Rezoning Transportation Analysis
Petition Number: Insert Zoning Petition #2021-213
General Location Identifier: 22706130

Revision Log:	Date	Revision Log:
	01/21/2022	First Review (WB)

The petition is located adjacent to Pineville-Matthews Road (NC 51), a State-maintained major thoroughfare, between Hugh Forest Road, a City-maintained Minor Collector, and Echo Forest Drive, a Private Local Road. The site is within the South Wedge outside Route 4. This site was previously rezoned in 1990, RZP-1990-008(C).

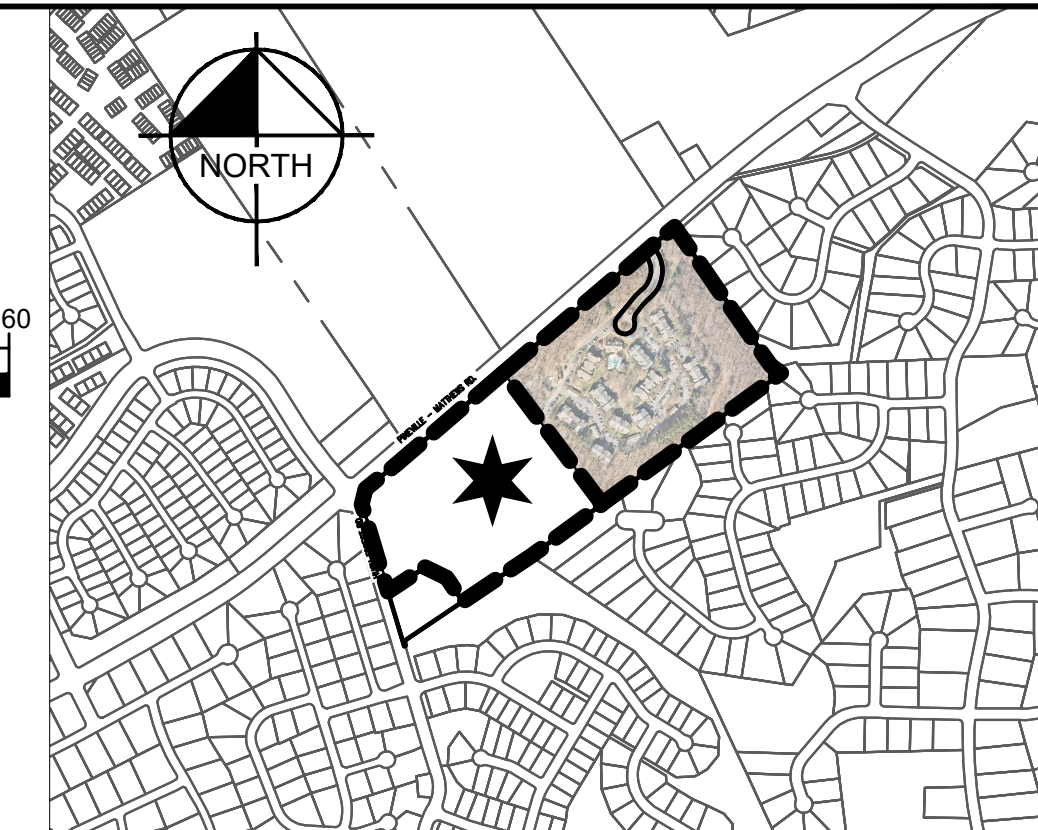
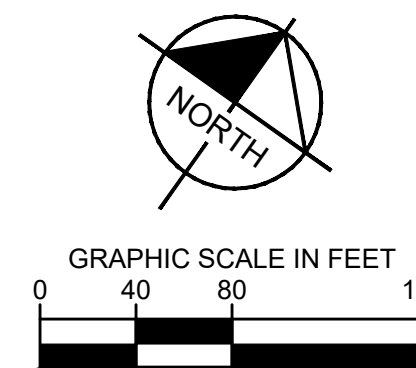
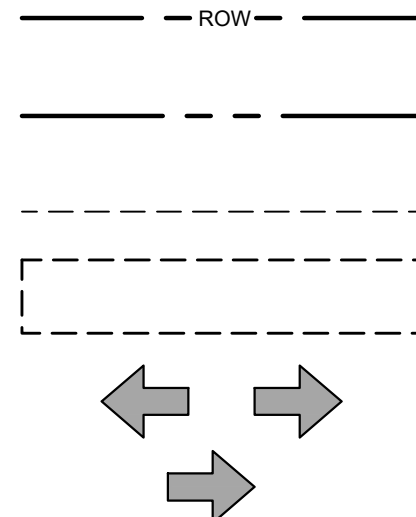
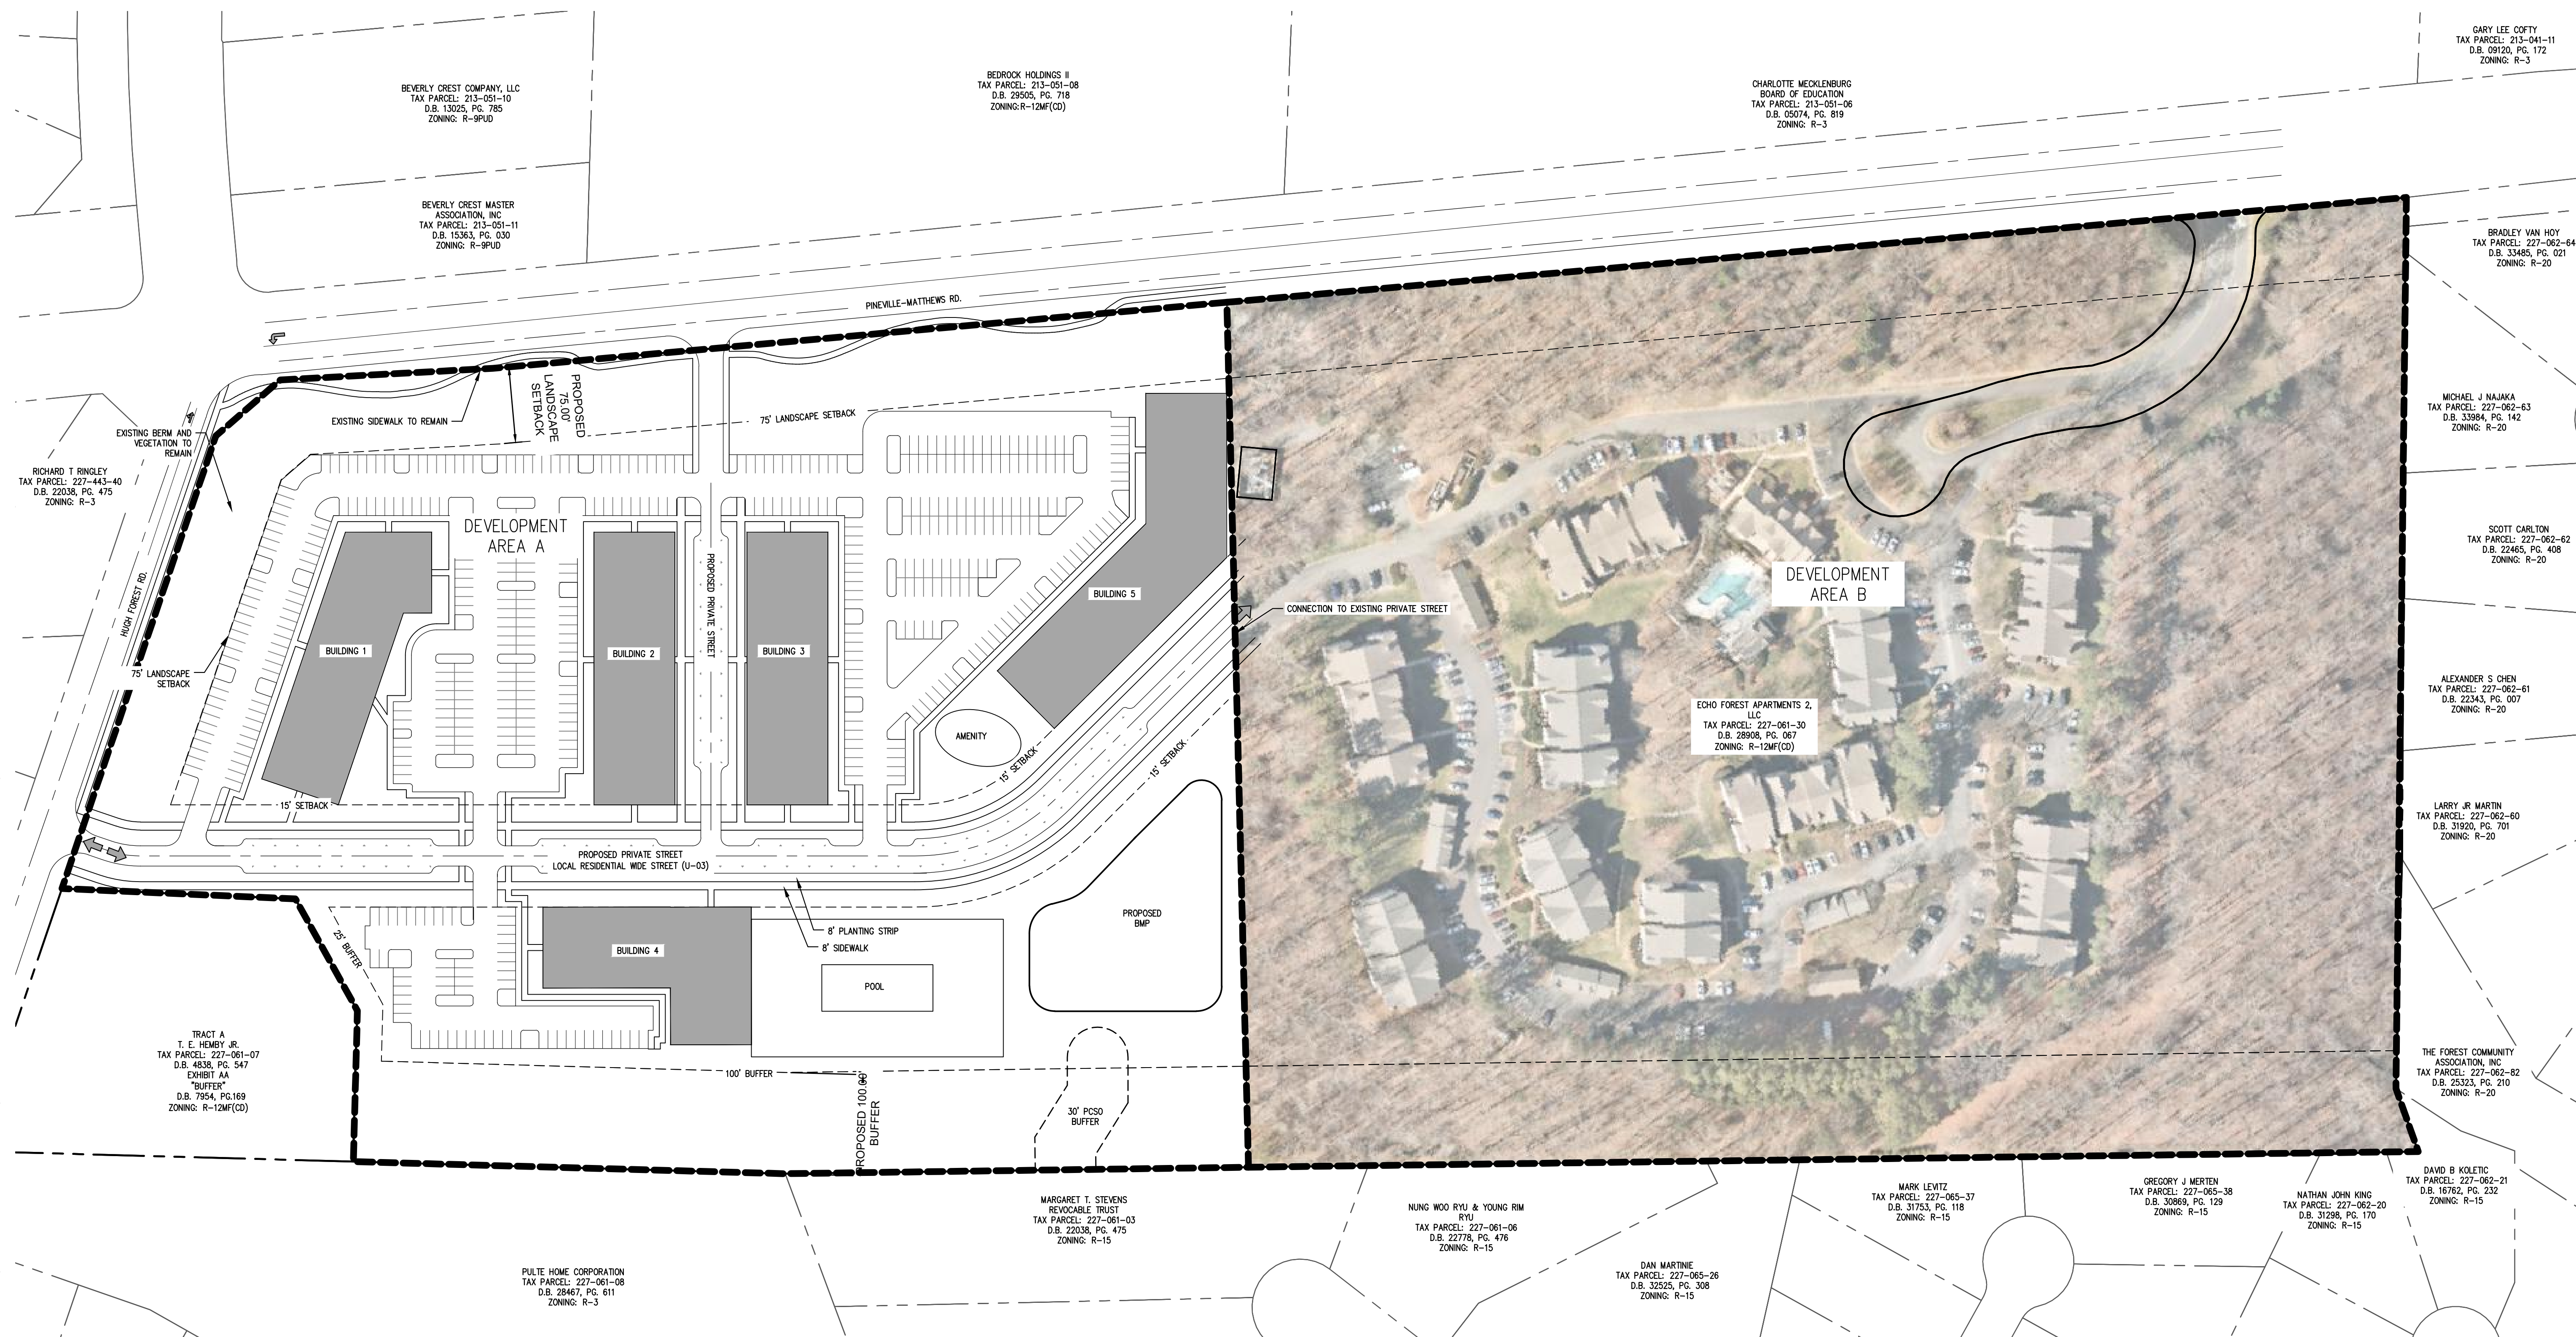
- Revise site plan and conditional notes to commit to dedicate 50-foot right-of-way from the Pineville-Matthews Road centerline. The site plan shall label and dimension the right-of-way from the road centerline.

- Revise site plan and conditional notes to commit to dedicate 36-foot right-of-way from the Hugh Forest Road centerline. The site plan shall label and dimension the right-of-way from the road centerline.

- Site plan and conditional note revisions are needed to commit to constructing two accessible curb ramps on the southeast corner of the Hugh Forest Road intersection per PROWAG and ADA law. Commitments to include all necessary works to bring the pedestrian crossing into ADA and PROWAG compliance, including crosswalk restriping.

- Site plan and conditional notes revisions are needed to commit to construct bicycle facilities by installing a 12-foot multi-use path along the site's entire Pineville-Matthews Road frontage in accordance with the Charlotte BIKES Policy.

- The proposed dwelling units exceeds 12 per acre. Per Chapter 20 Subdivision ordinance, site plan and conditional note revisions are needed to commit to construct an 8-foot sidewalk with an 8-foot planting strip along Hugh Forest Road. The wider sidewalk also meets the Charlotte WALKS Policy.

- 7. Revise site plan and conditional notes to commit to constructing a right turn lane on Pineville-Matthews Road into the proposed driveway per NCDOT standards.

- 8. Revise site plan and conditional notes to commit to constructing a right turn lane on Pineville-Matthews Road into the Echo Forest Drive per NCDOT standards.

- 9. Revise site plan to adequately depict and label existing facilities, including the Echo Forest Drive, the signalized intersection at Echo Forest Drive, and the existing School Driveway.

- 10. The egress movement at Echo Forest Drive shall be limited to 'left out and right out' only to mitigate the increase in traffic at the existing signalized intersection. No northbound through movements will be encouraged. Petitioner to install a concrete channelization island per NCDOT standards to enforce the restricted movement.

- 11. Site plan and conditional note revisions are needed to include the construction of two ADA Curb ramps on each corner of the Echo Forest Drive intersection on the south side of Pineville-Matthews Road per PROWAG and ADA law. Petitioner to coordinate with CIP Project on the construction of ADA facilities.
